Application No: FN/4/09/

PLANNING APPLICATION REPORT

LOCATION: 71 High Street
Findon

PROPOSAL: Extensions and alterations

FIRST FLOOR PLAN

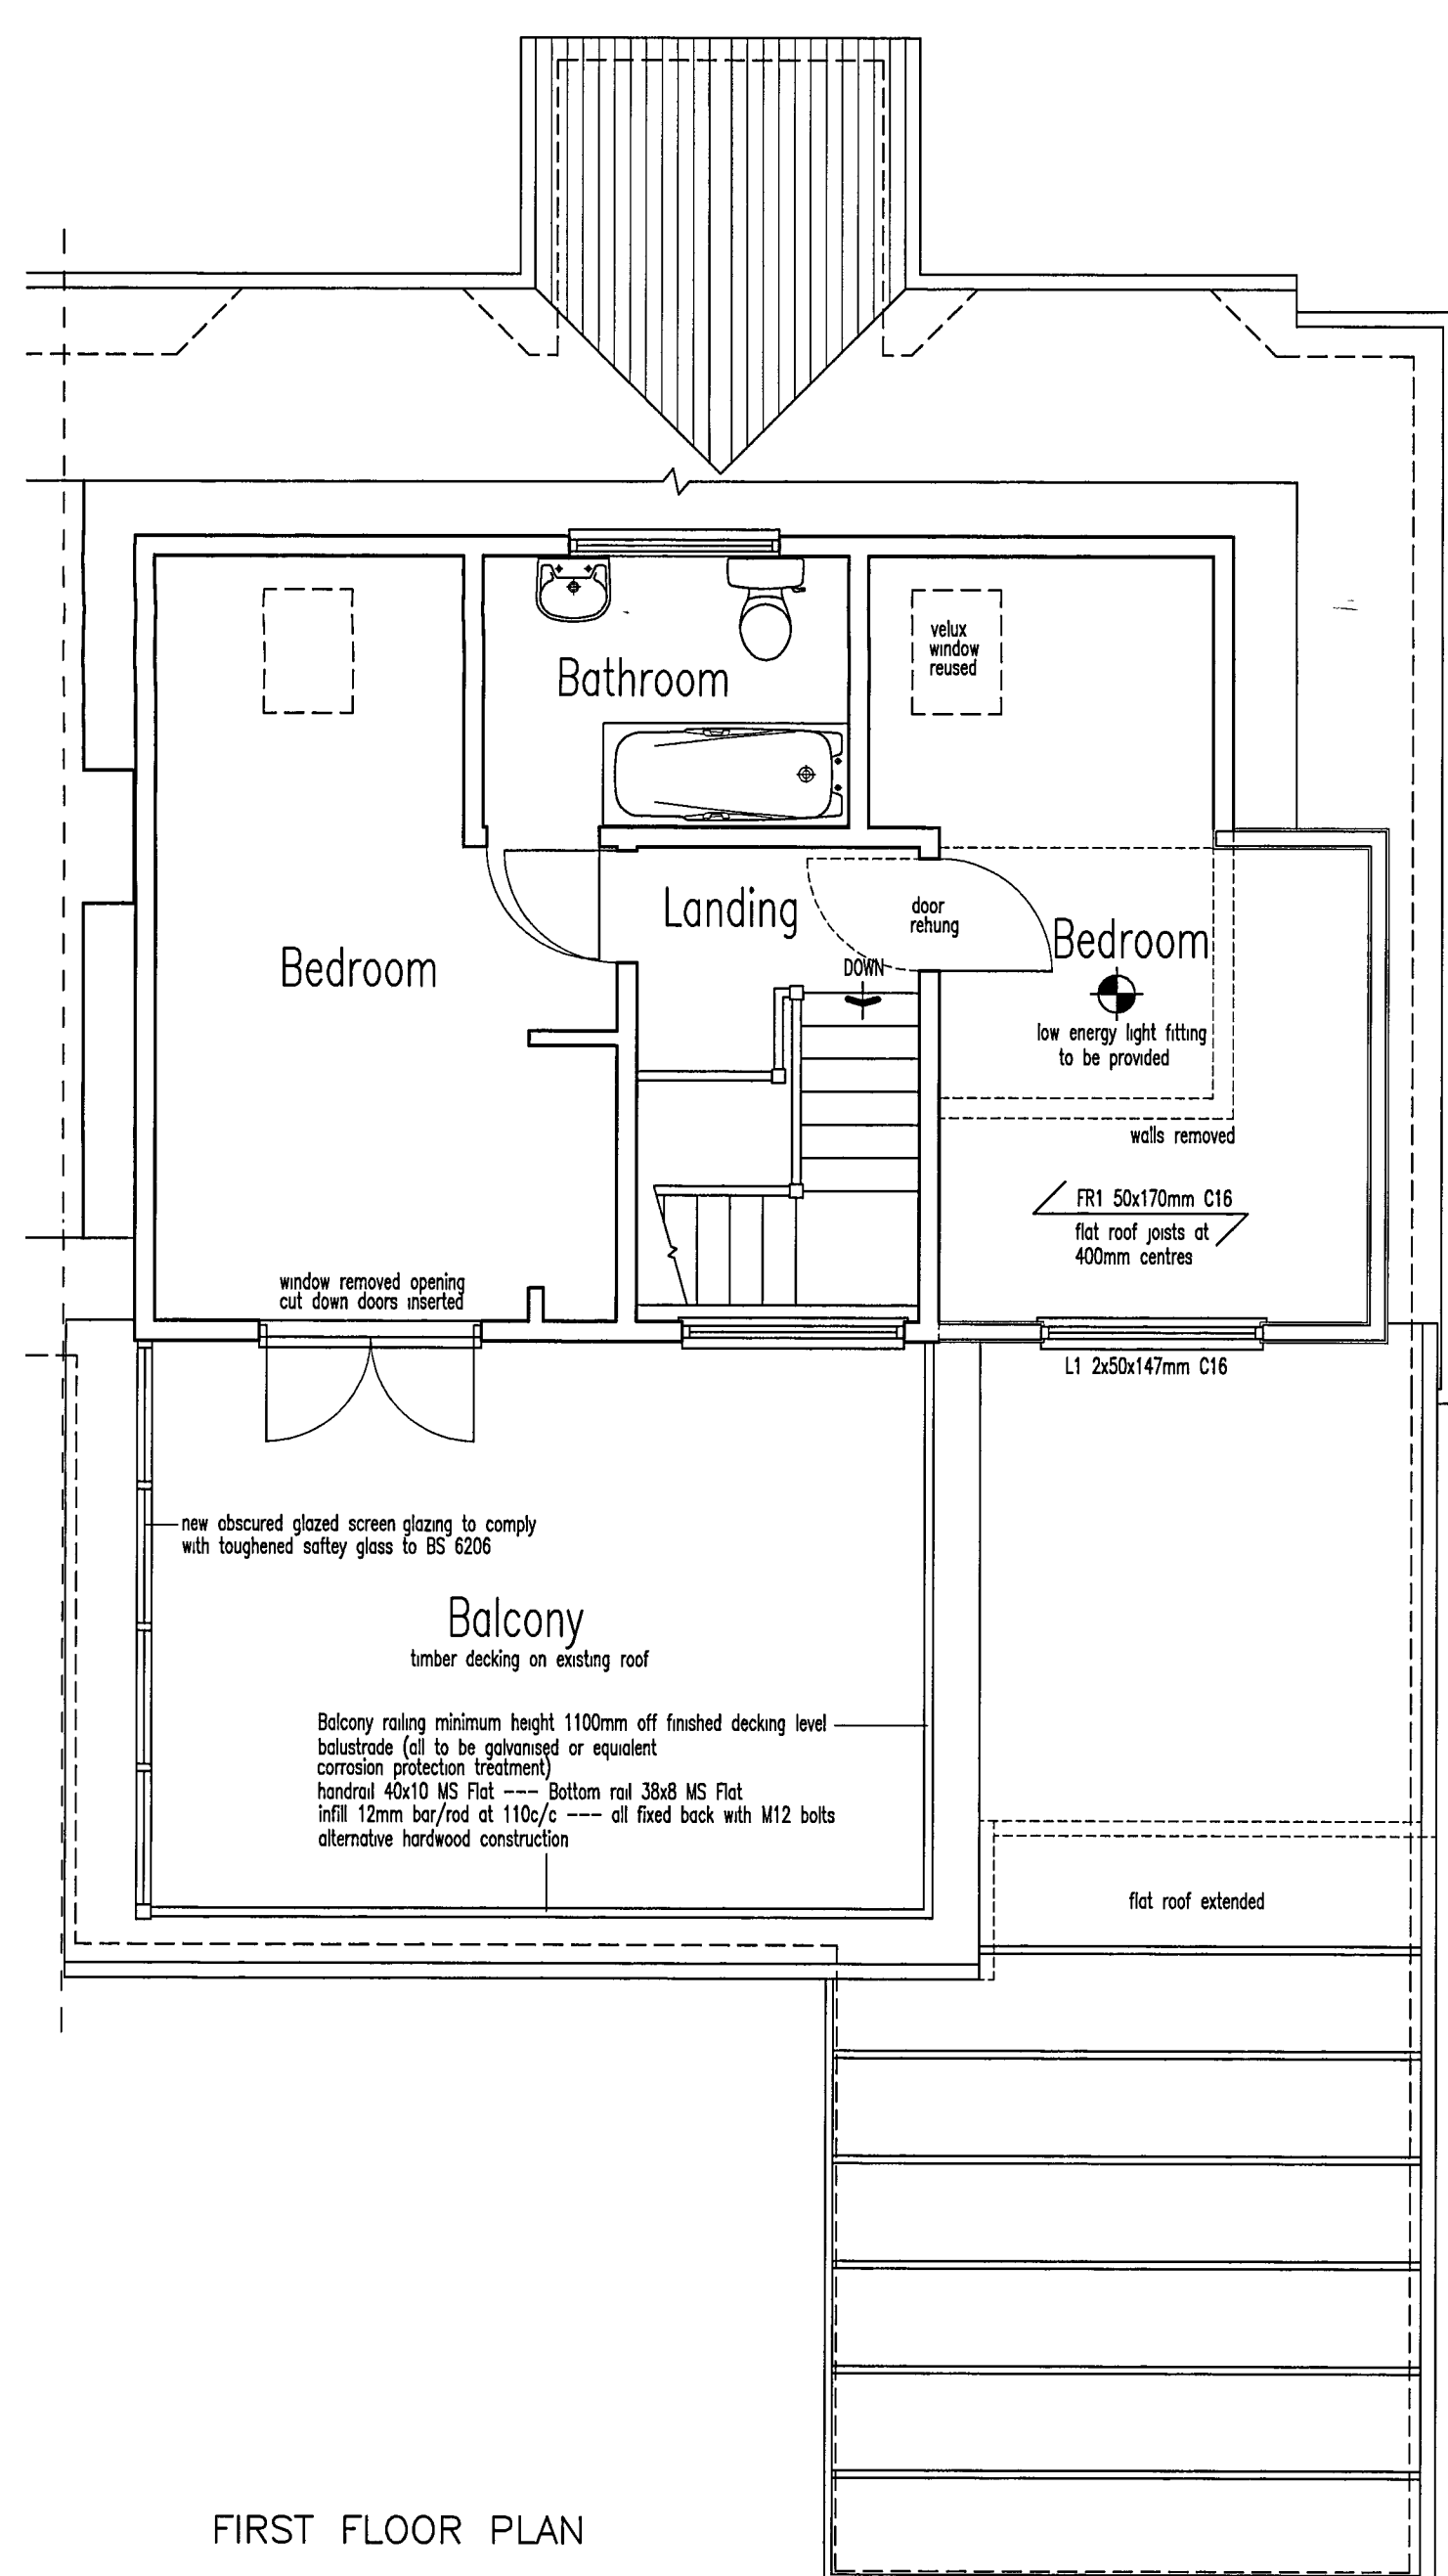
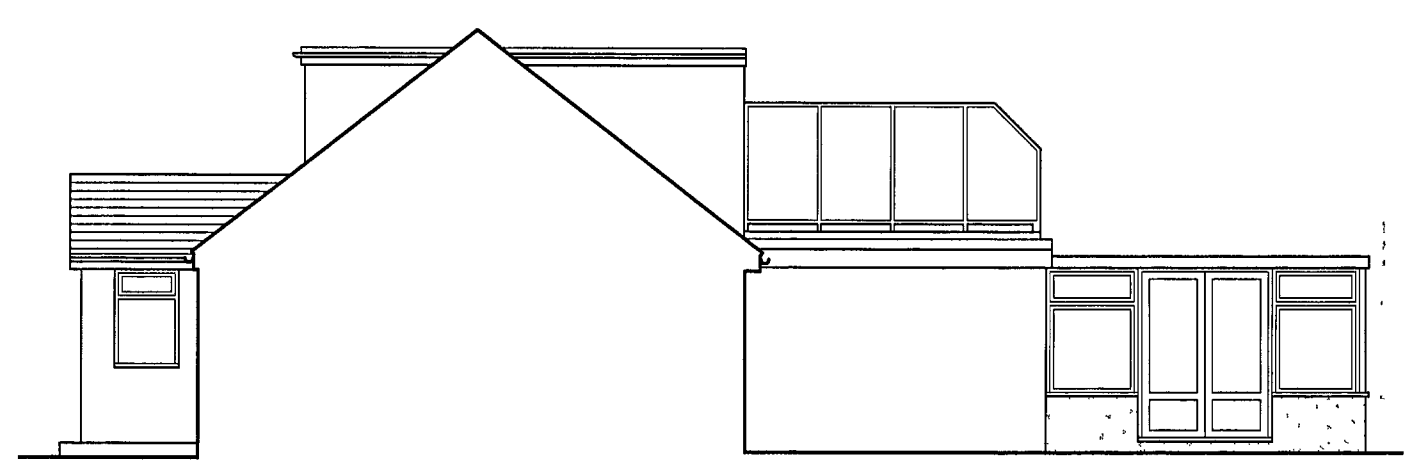
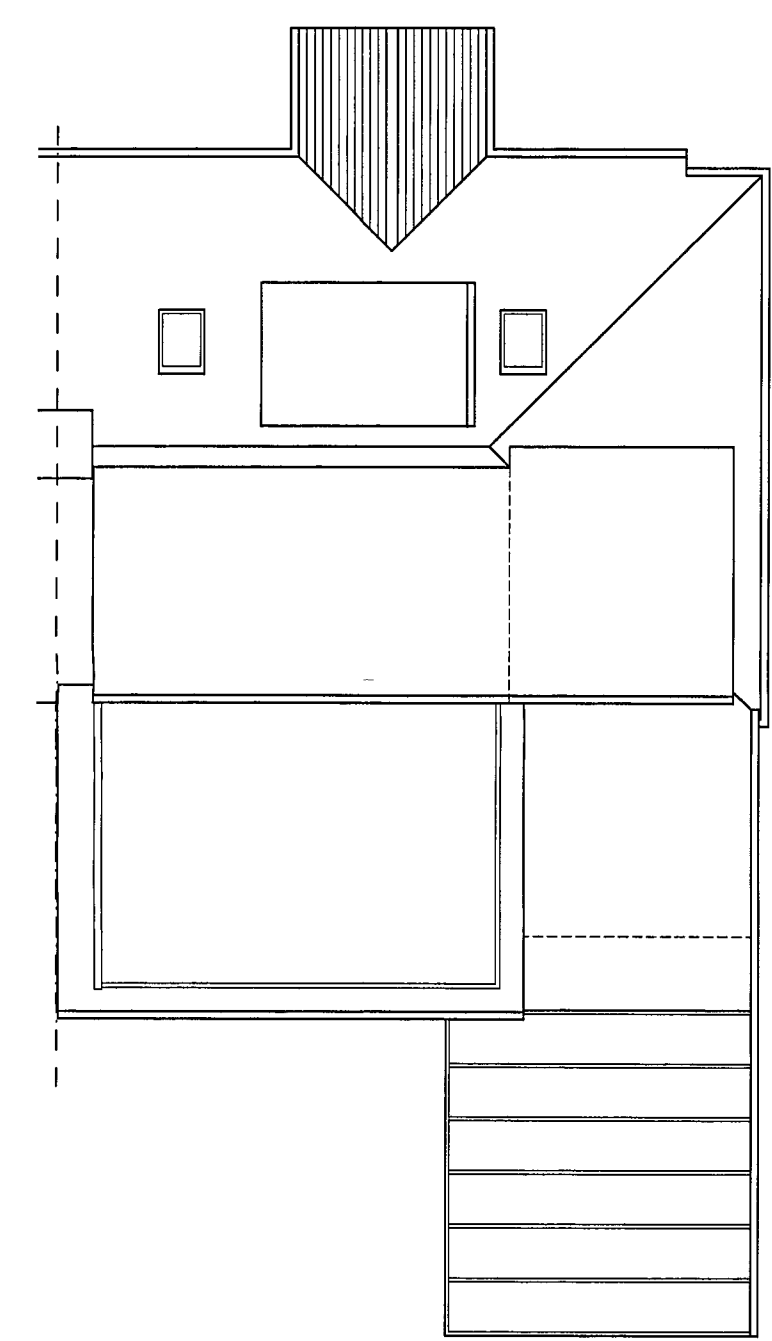
The wording of the application is deceiving to neighbouring residents. The original application stated Extensions and Alterations. A balcony/terrace has been constructed on the existing flat roof and 1 window has been changed into a door to allow access onto the roof. Objection to the balcony as it would look directly into neighbouring back door and impinges on privacy.

Objection: The proposed balcony may be overlooking and overbearing and as such would not comply with Arun District Local Plan Policy GEN7.

Comments noted. The balustrading and door have been provided ahead of any planning permission and it is at the owners risk to do so.

Noted. 1.8 metre high obscured screening is proposed to be installed on the eastern edge of the balcony facing towards the neighbouring property to alleviate and reduce any possible overlooking. The balcony itself will be set upon an existing single storey structure and although it will come to within approximately 500mm of the neighbouring property to the east, it is considered that the structure would not appear unduly overbearing.

- 3 The balcony hereby permitted shall not be brought into beneficial use until a 1.8 metre high obscured balcony screen has been sited along the entire eastern extremity of the balcony in accordance with details that shall first have been submitted to and approved in writing by the Local Planning Authority. The balcony screening shall thereafter be retained in perpetuity.
